CITY OF ALBUQUERQUE

February 12, 2021

Re: Valencia (Active Adult Community (K18D080))

Based upon the information provided in your submittal received 2-11-2021, the above referenced plan cannot be approved for a construction permit until the following comments are addressed:

NORTH  
A1 SITE PLAN  
1" = 20'  
0 10' 20' 40'

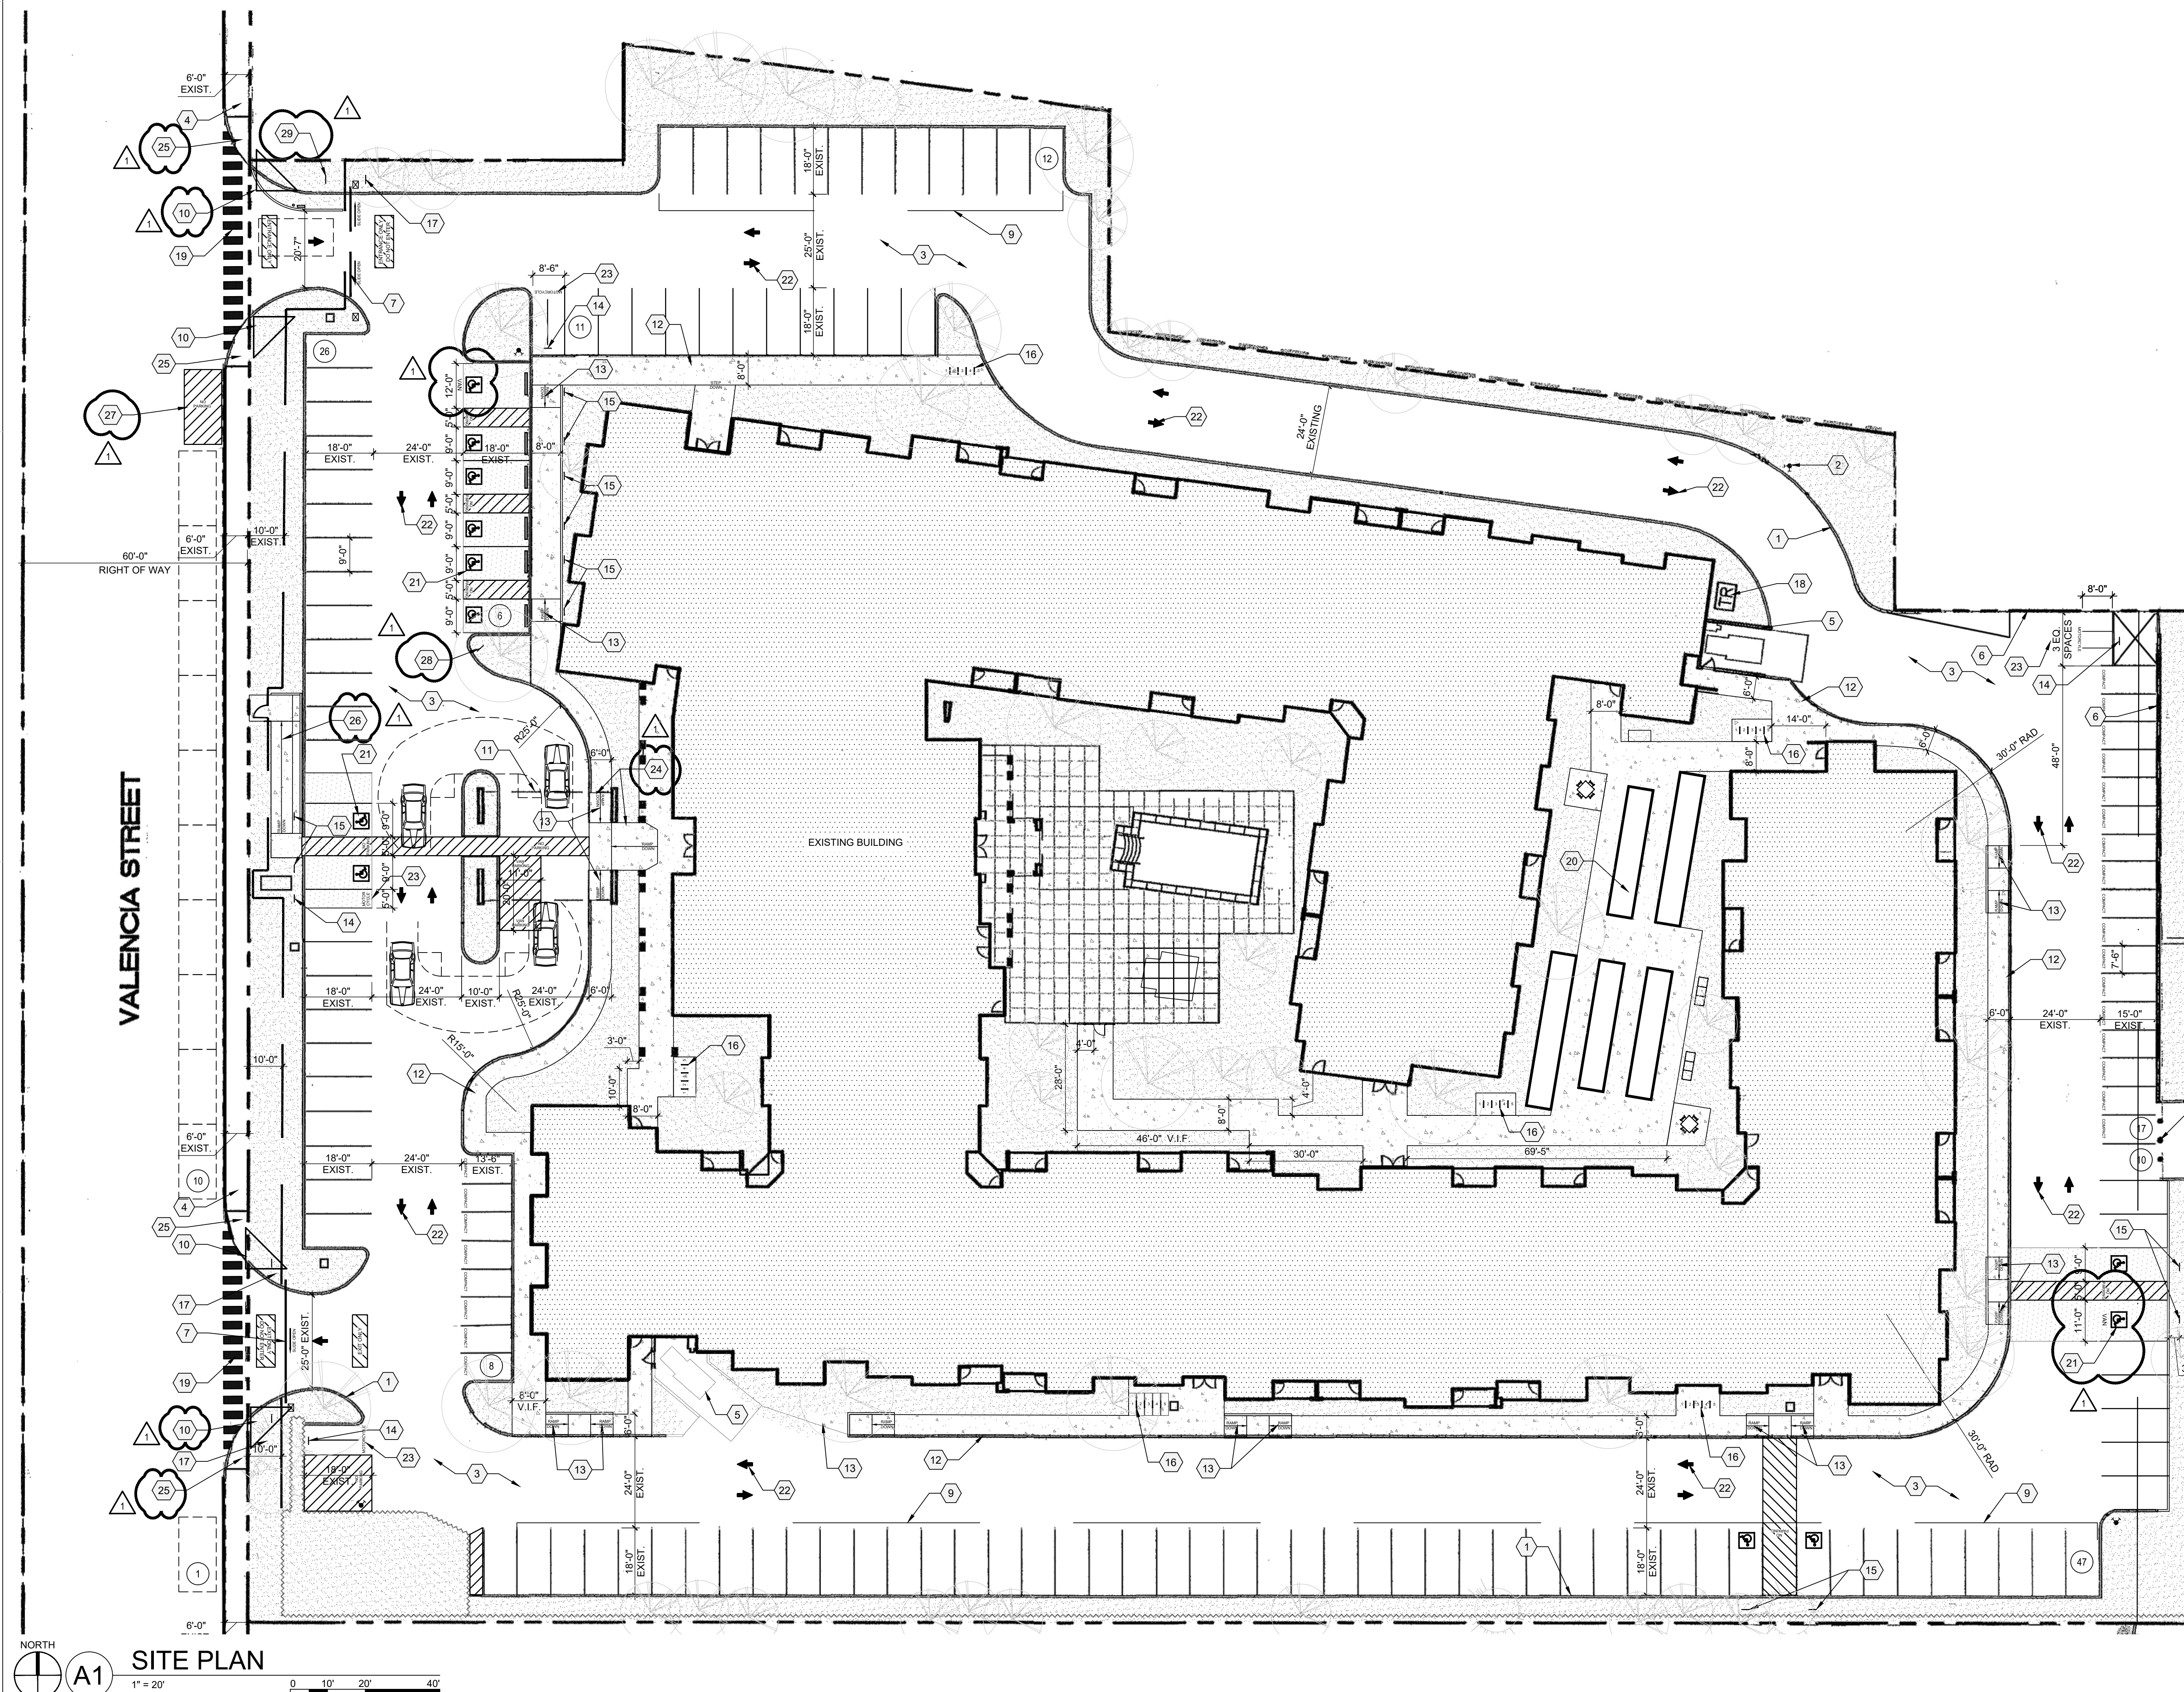
1. Even if existing, obtain Fire Marshall and Solid Waste Approval prior to Traffic Circulation Layout approval.
2. What is the reasoning behind the placement of the exit versus the entry for this development? It would make the traffic circulation challenging for drop-offs on the west side of the building.

4. Why do the parking calculations show 188 required spaces, but only 148 spaces are provided? List number of units, and check parking requirements under the IDO for Active Adult Living/Group Living.

5. Show sight distance triangles behind the sidewalk projected to curb per the mini clear sight triangle diagram in the DPM. Add the note, "Landscaping, signage, walls, fences, trees, and shrubbery between three (3') and eight feet (8') tall (as measured from the gutter pan) are not allowed within the clear sight triangle."

8. Label motorcycle parking signage on the plan, and call out "MC" on the back of the motorcycle spaces.
9. For all handicapped aisles, show width of all aisles to make a distinction between the 5-foot aisle and the van accessible aisle.

10. Call out width of existing sidewalk along Valencia and existing curb ramps.
11. For any one-way aisles, label directional arrows, and use a "Do Not Enter" sign on each side of the drive. Also place one-way signs.

12. Current gate locations (though existing) do not allow for queuing between gate and street/crosswalk. The Transportation is requesting gate relocation for safety purposes. Also, for clarification, will the gates only be closed during certain hours?

SITE PLAN DETAILS

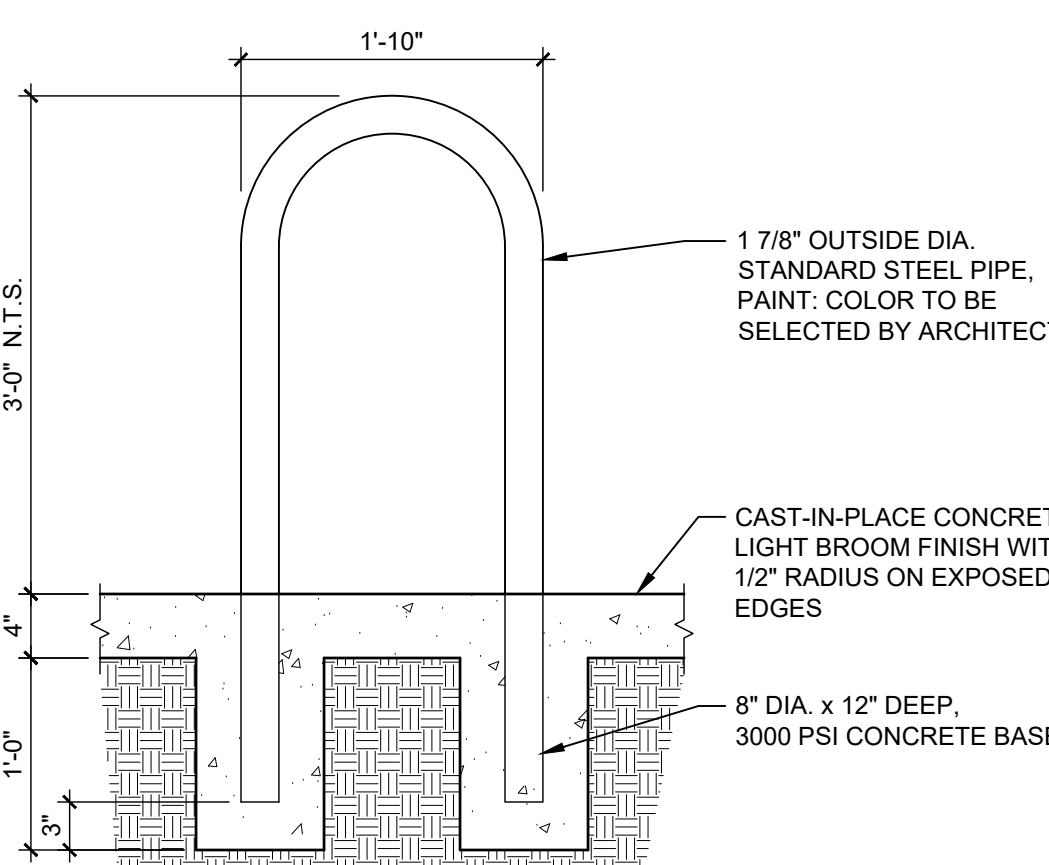
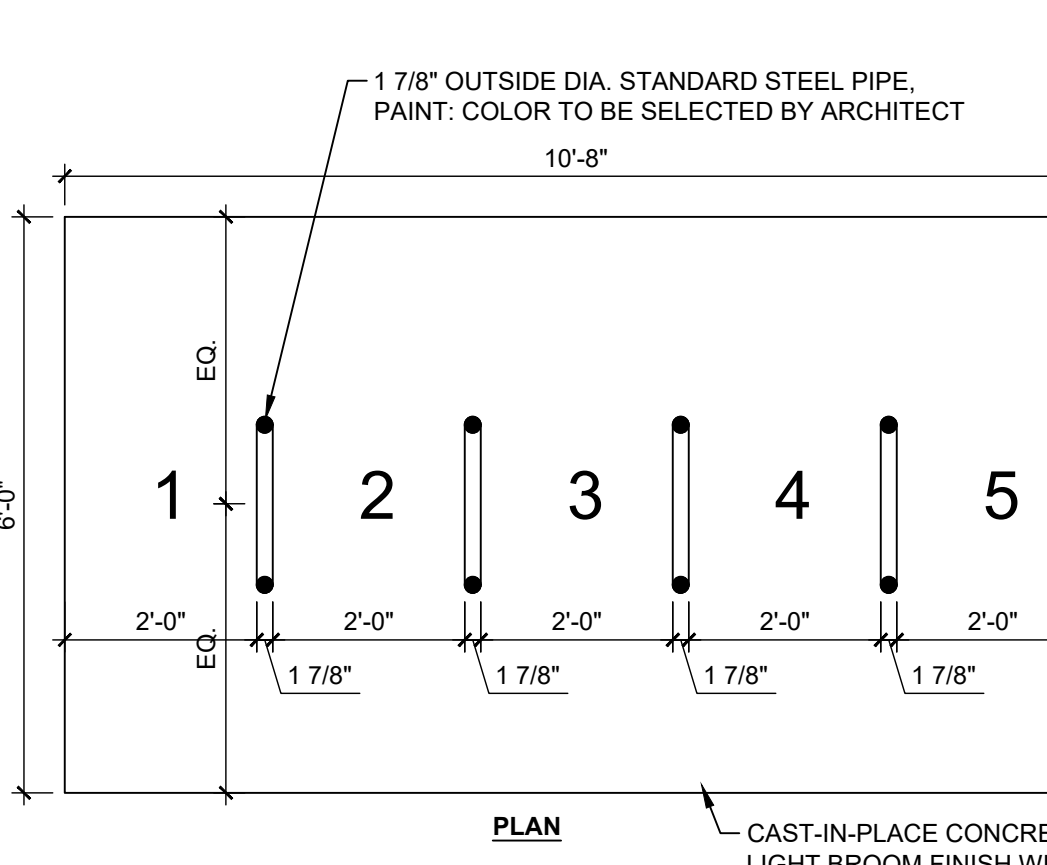
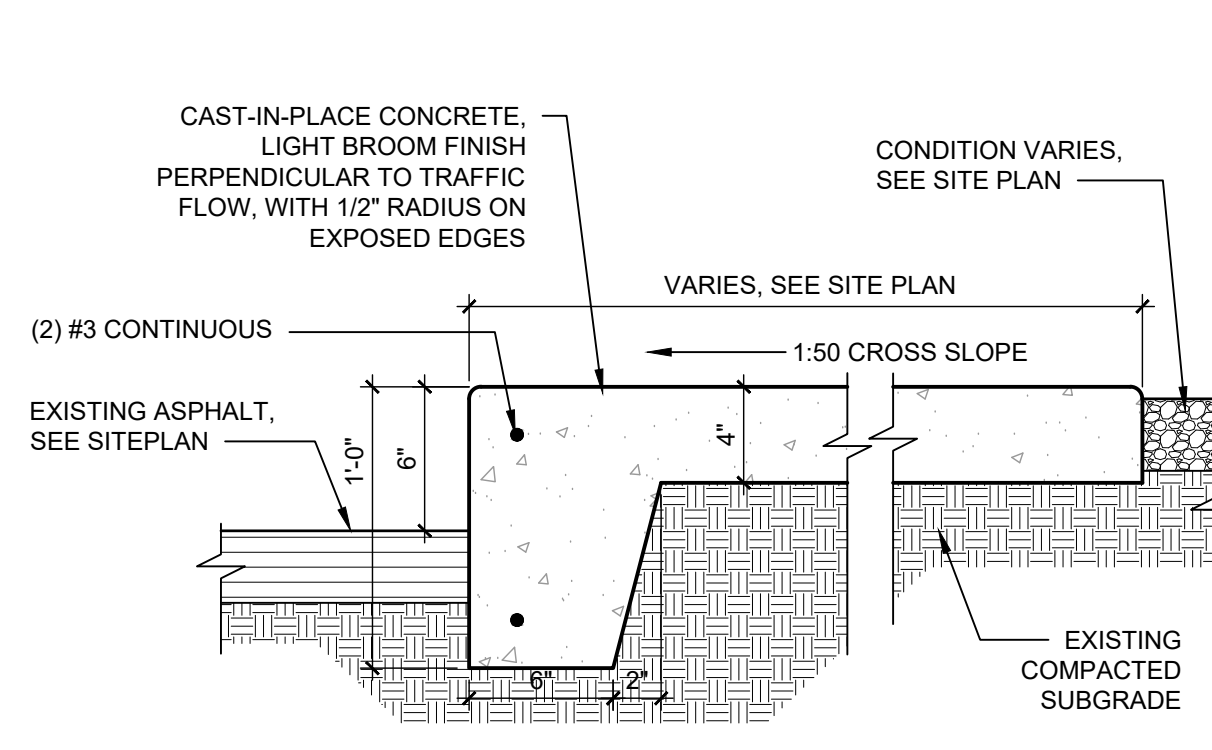
6. Call out bike rack as part of the keyed notes.
7. Provide detail sheet with bike rack, curb ramps, and sidewalk. Sidewalk shall be shown to be a maximum cross-slope of 2%.
